**SECTION 96(1A) MODIFICATION APPLICATION SSD - 6724
60-78 REGENT STREET, REDFERN**

On behalf of Iglu Pty Ltd, we hereby submit an application pursuant to section 96(1A) of the *Environmental Planning and Assessment Act, 1979* (EP&A Act) to modify State Significant Development Consent SSD 6724 relating to the construction of an 18 storey student accommodation building with retail and community space at ground floor at 60-78 Regent Street, Redfern.

2.0 PROPOSED MODIFICATIONS TO CONSENT

60-78 Regent St
Redfern
North Elevation

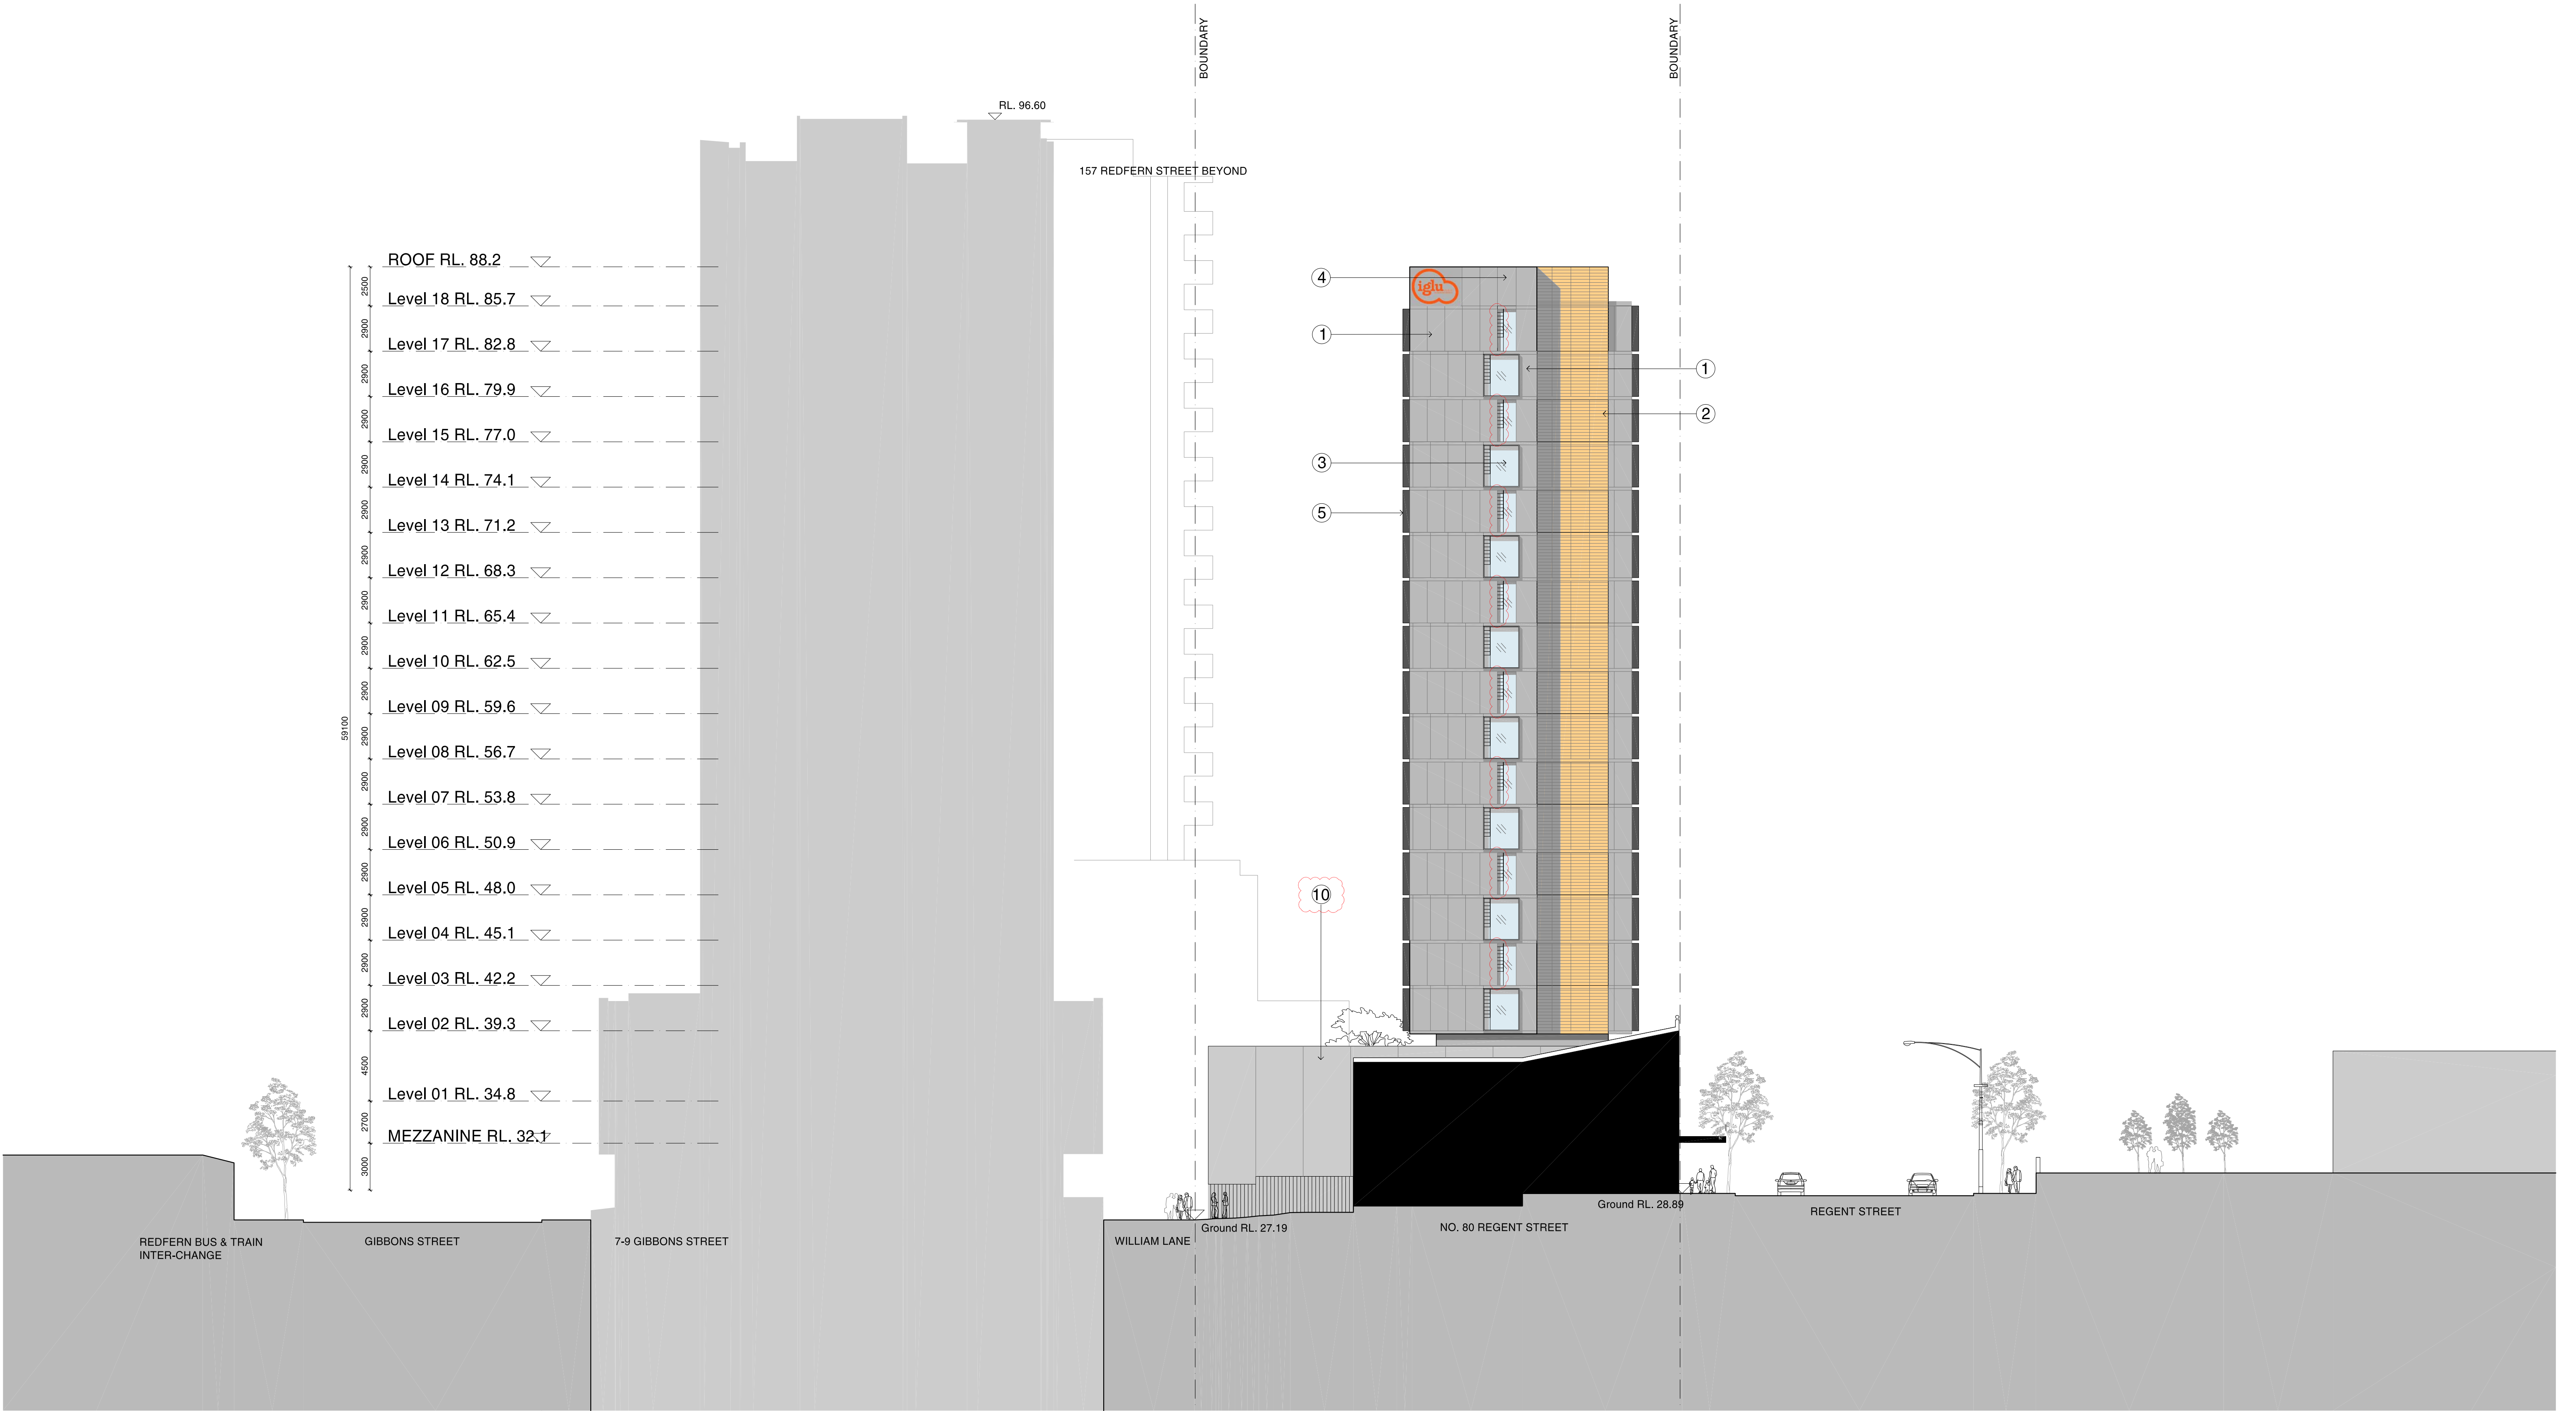
Reception/office connects to rear facade, windows added to facade
East Elevation	Shopfronts changed to single-door system
	Awning in front of lobby deleted
	Lobby height reduced
	FBPV/metres door cladding is aluminium louvers in lieu of solid cladding to allow required ventilation
West Elevation	William Laneway facade updated to include switch room louvered doors. Windows to former community room deleted.
	Gate added in lieu of glazed doors
	Windows at Level 1 changed configuration to become awning windows
	Windows/louvers added to reflect changes to Level 1 admin and Level 1 stair pressurisation fan room
	Building height amended in accordance with Condition B4.
North Elevation	Material changed to boundary wall (brick to precast concrete)
	Building height amended in accordance with Condition B4.
South Elevation	Material changed to boundary wall (brick to precast concrete)
	Louvre added to existing window at Levels 3, 5, 7, 9, 11, 13, 15, 17

60-78 Regent St
Redfern
Ground Floor Plan

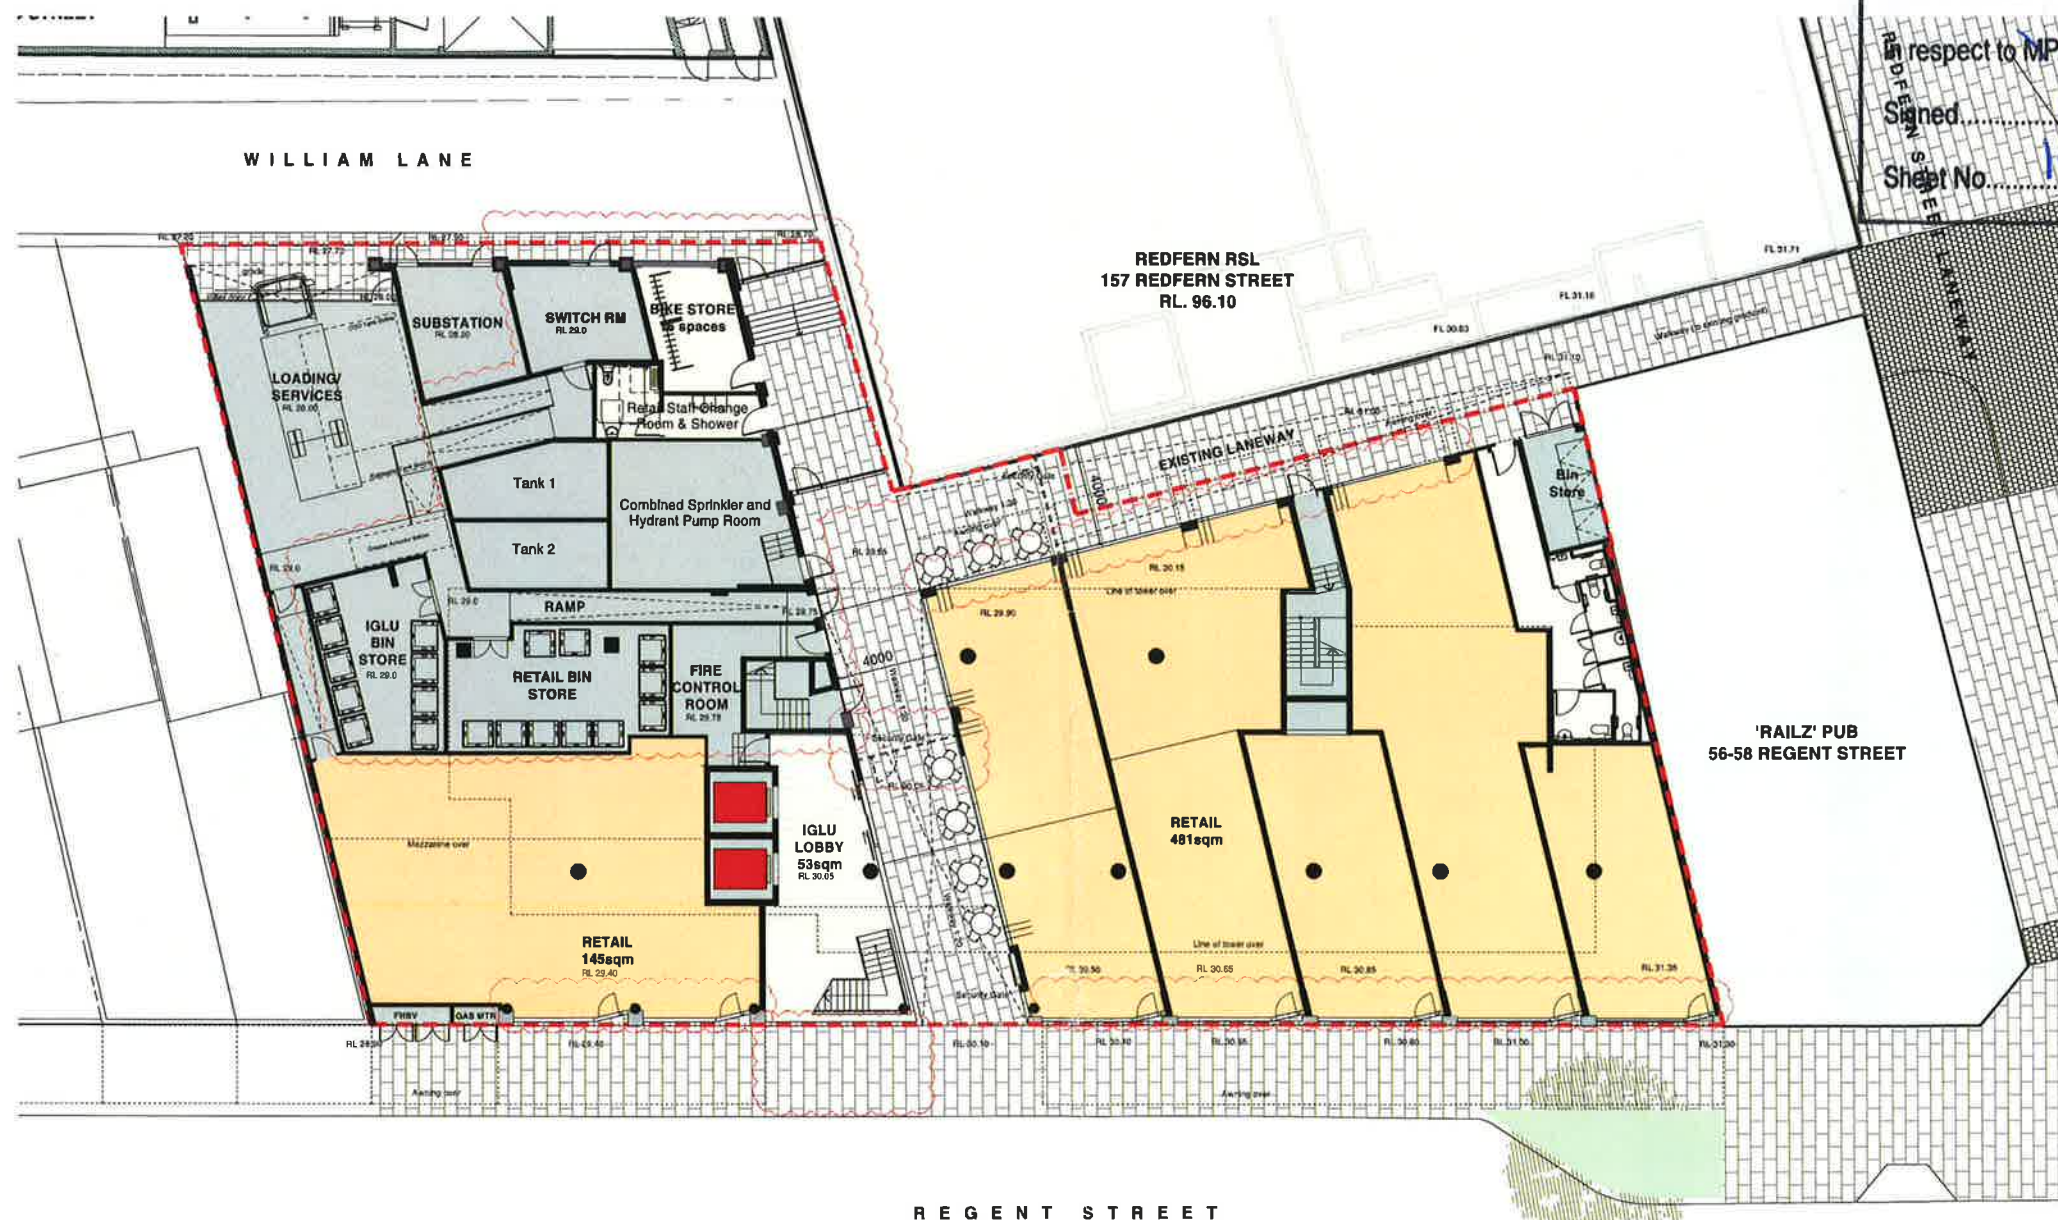
Floor	
Basement/ Ground Floor	Basement deleted (except lift overrun) and plant/service areas relocated to Ground and Mezzanine
	Ground level back-of-house areas re-planned – Iglu community room moved to Level 1
	Ground level security gate (near Regent St) moved back into laneway so that it is located under Level 1, enabling full height security
	Regent Street shopfronts changed to achieve consistent single-door shopfront design
	Rear laneway shopfronts have bi-fold doors instead of approved double swing doors
	Connection to William Lane is open to sky (roof removed) and restricted to staff access only
	Detailing of retail staff change rooms and shower facilities
Mezzanine	Required fire egress stair added
	Required stair pressurisation fan room added
Level 1	Iglu community space/gym relocated from Ground Floor
	Minor replanning of internal rooms
	Required stair pressurisation fan room added to rear of northern stairwell

60-78 Regent St.
Redfern
Basement Plan

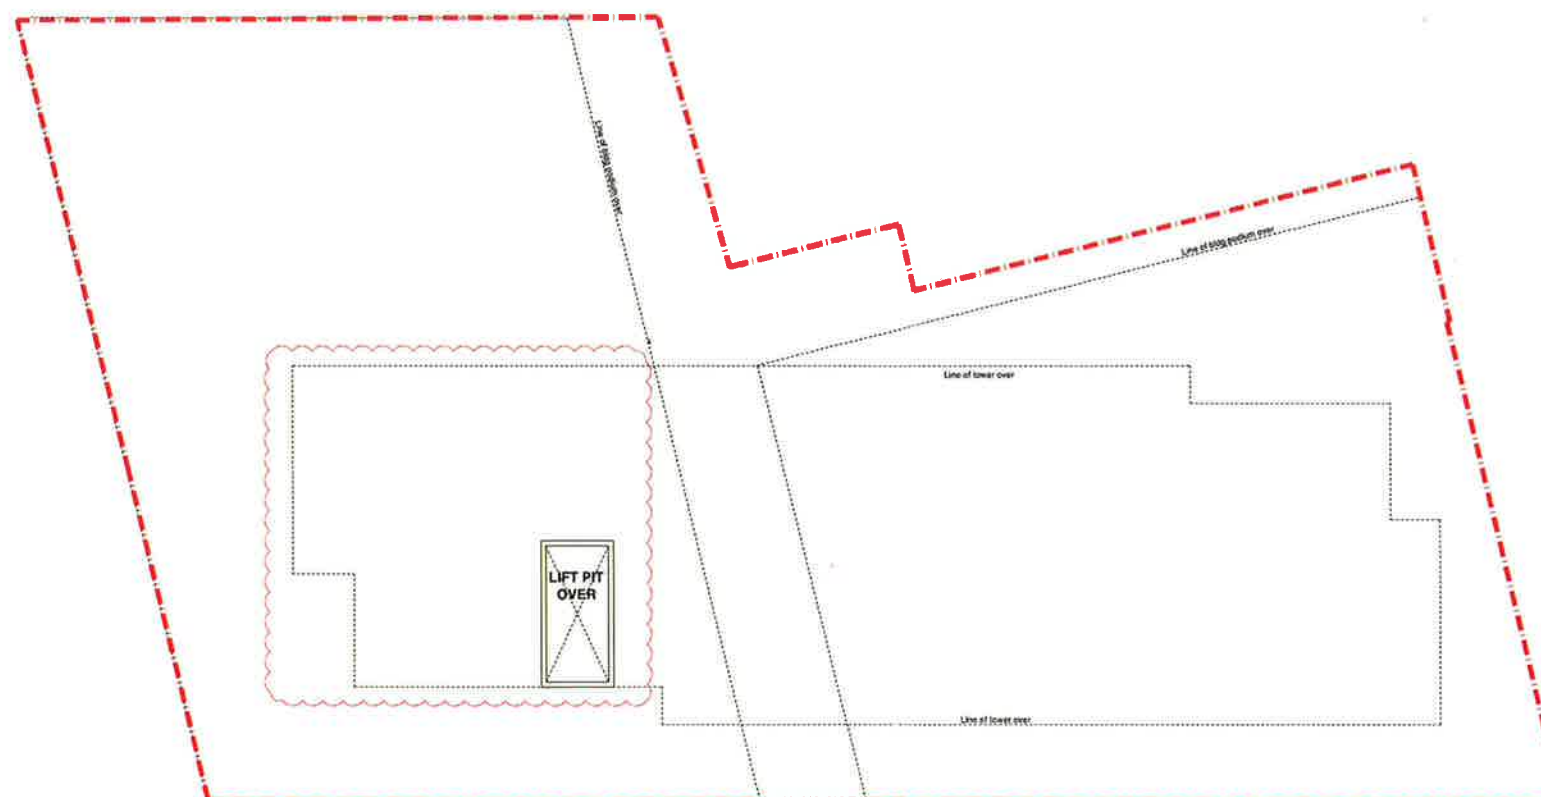
- Re-planning of the basement and ground level plant and service areas to reduce the extent of basement excavation, resulting in minor internal reconfiguration and relocation of Iglu's community space to level 1.
- Minor amendments to retail tenancy shopfronts glazing and framing systems.
- Minor internal changes for servicing throughout the building.

60-78 Regent St
Redfern
West Elevation

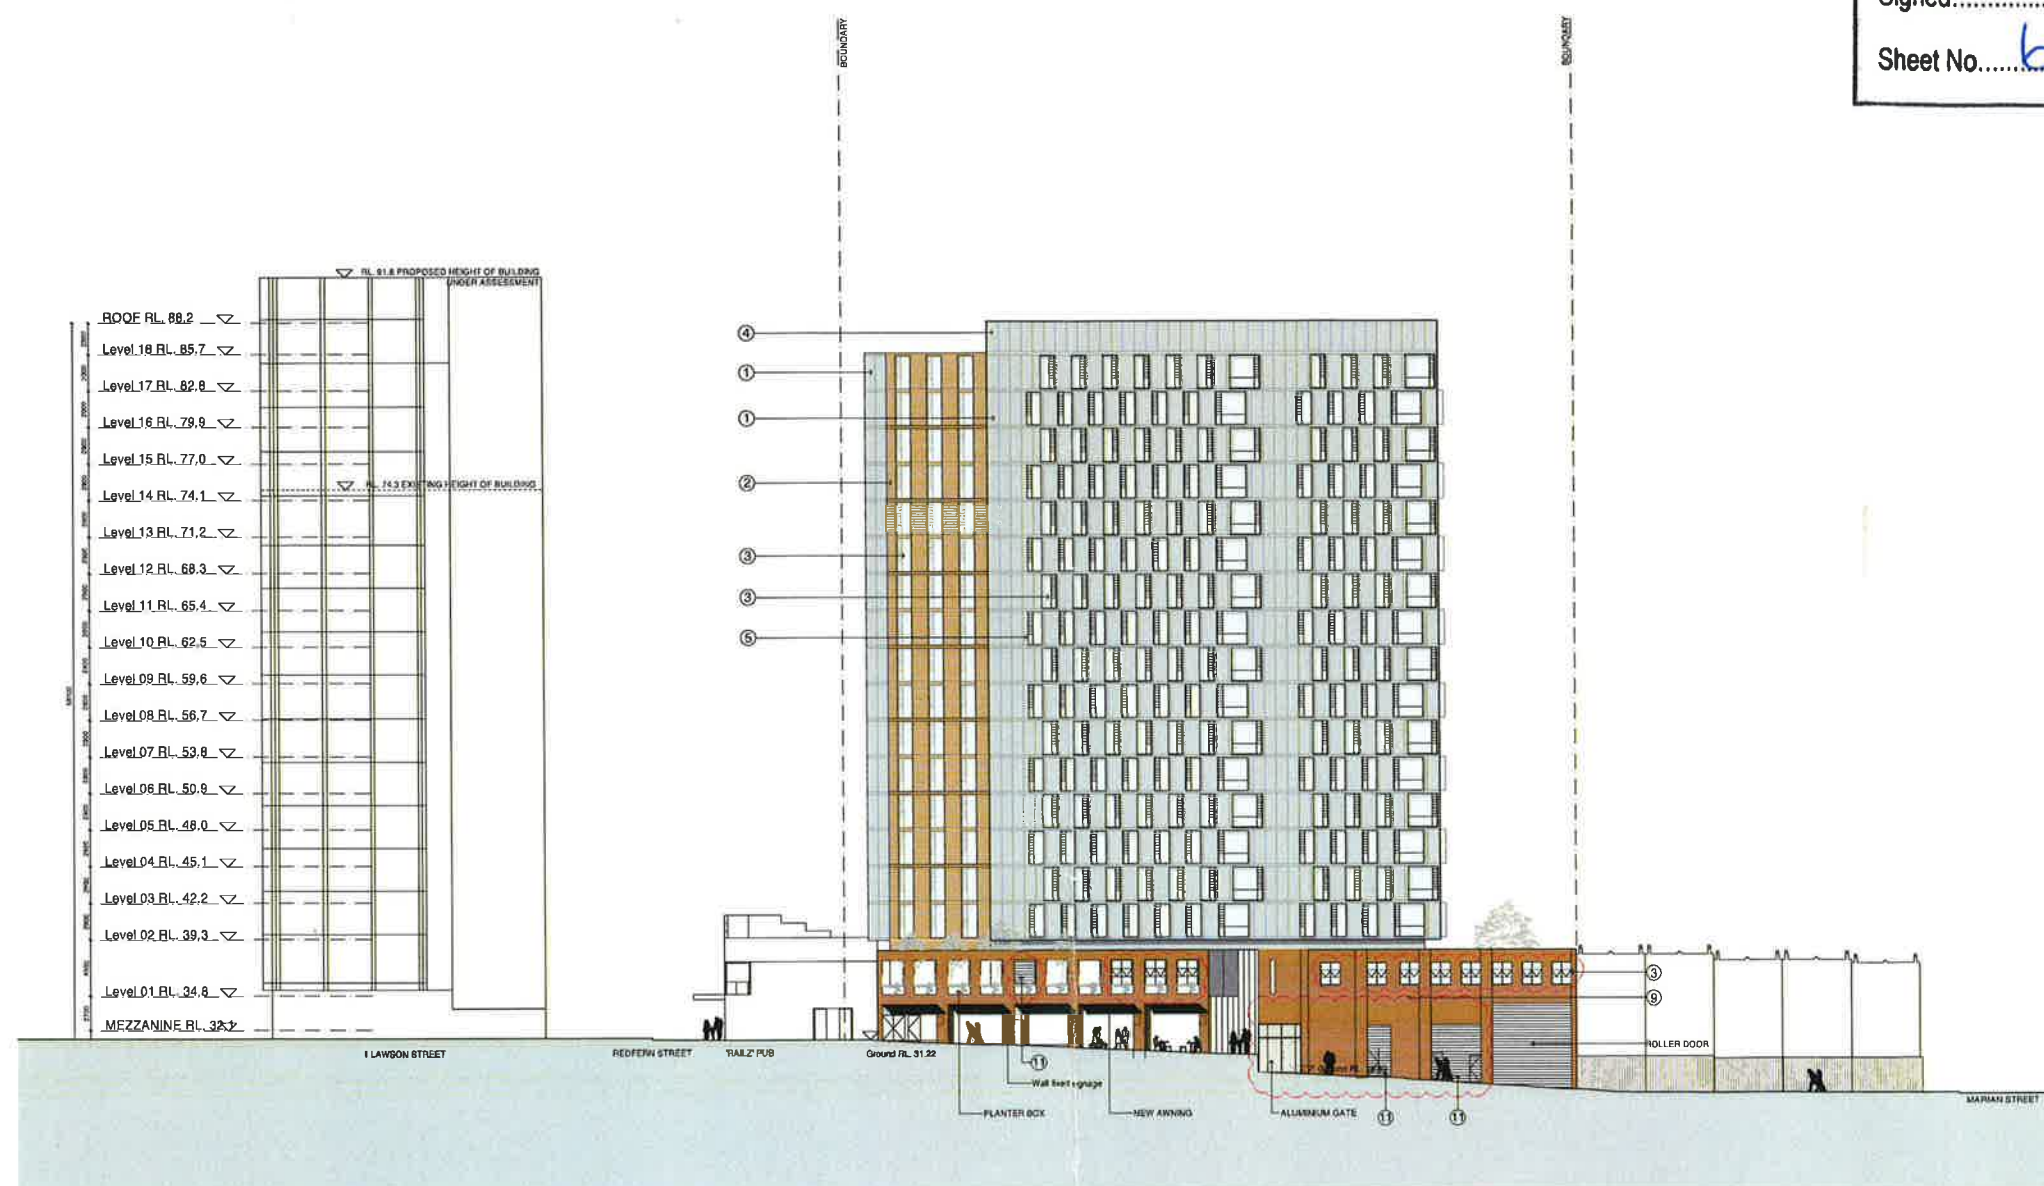
- Modifications to the retail shopfronts (comprising a change to the framing system) will not alter the overall connection with and presentation to Regent Street and will continue to make a positive contribution to the activation of this street.
- The replacement of two windows to William Lane with aluminium louvers is a result of the consolidation of plant rooms on the ground floor. Given that William Lane is predominately a service lane for vehicular access and servicing, this material treatment is considered to be consistent with the character and function of this street and is therefore an acceptable change.
- Restriction of access to staff only in the pedestrian corridor between William Lane and the internal laneway will provide for clearer and safer pedestrian movements within the ground plane and is consistent with the submission from NSW Police on the original DA.
